PLANNING CONSULTATION RESPONSE

Application No	2025/1023
Proposal	Part change of use from dwellinghouse (Use Class C3) to small-scale childminding business (RETROSPECTIVE).
Address	51 Fish Dam Lane, Monk Bretton, Barnsley, S71 2PY
Date of Consultation Reply	16/12/2025
Consultee	Highways Development Control

BLOCK PLAN
SCALE 1:500

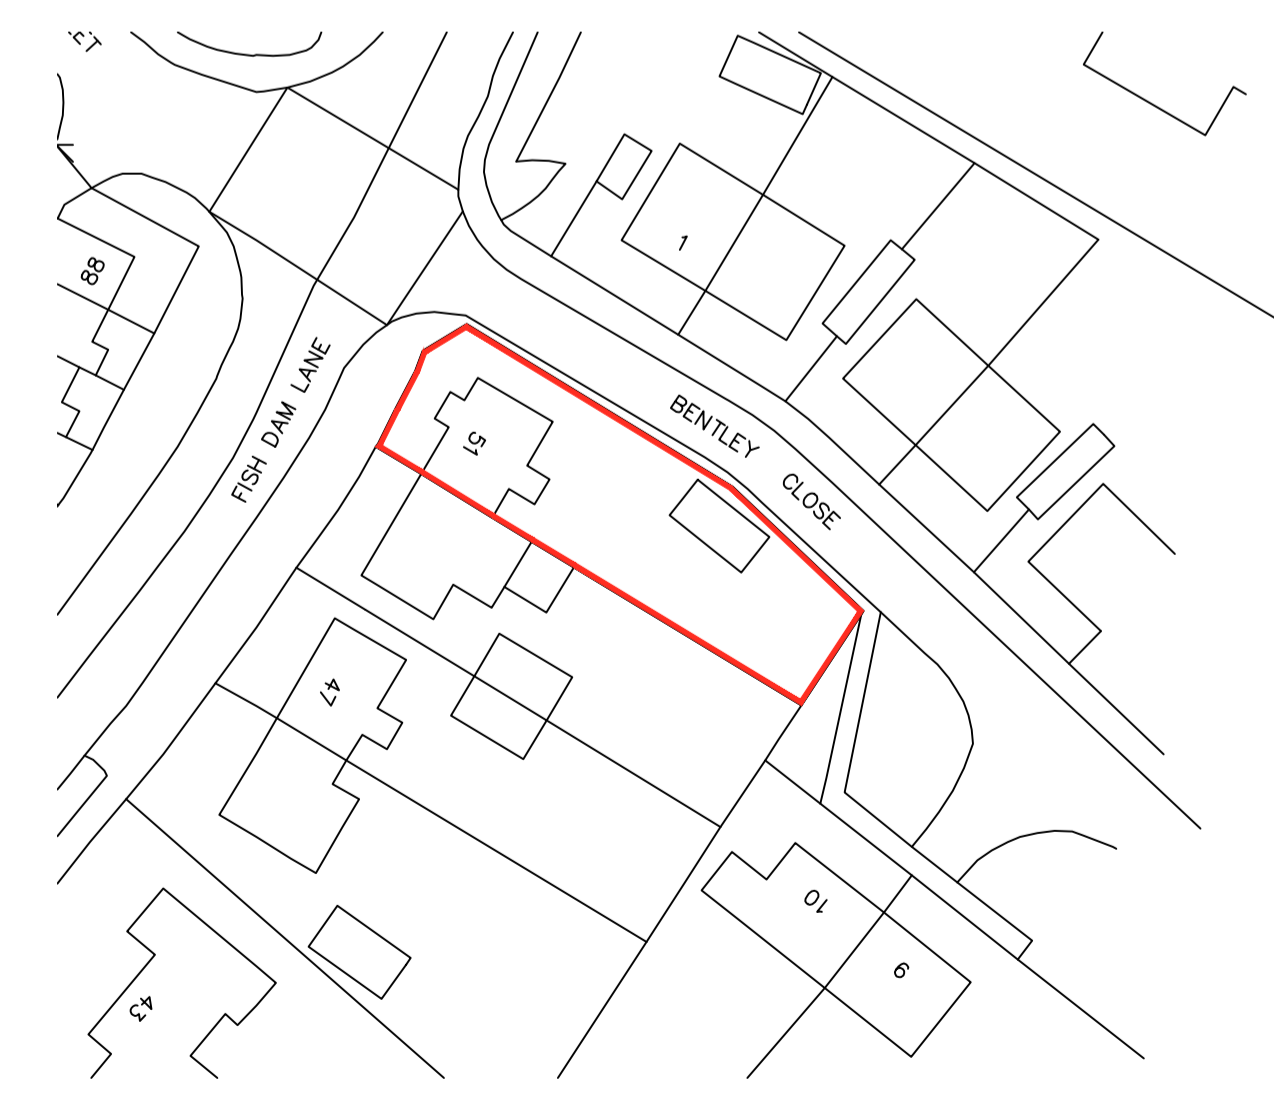
The submitted site plan indicates that on-site turning provision exists. However, this turning area is compromised by the introduction of parking spaces for staff vehicles. As a result, vehicles associated with drop-off and pick-up activity would be unable to turn within the site and would be required to reverse either onto or from Fish Dam Lane, at or in close proximity to a junction where visibility is already poor. This arrangement gives rise to an unacceptable

level of conflict with through traffic, including buses, and presents a clear highway safety concern.

Whilst it is recognised that the property has an established access, this access is substandard in terms of visibility and was designed to serve a single residential use. The proposed childminding use represents an intensification of vehicular activity, particularly during peak periods, which directly exacerbates existing deficiencies. The loss of effective on-site turning provision, combined with constrained visibility and the site's location on a classified road at a junction, results in a materially worse situation than if it was the residential use alone.
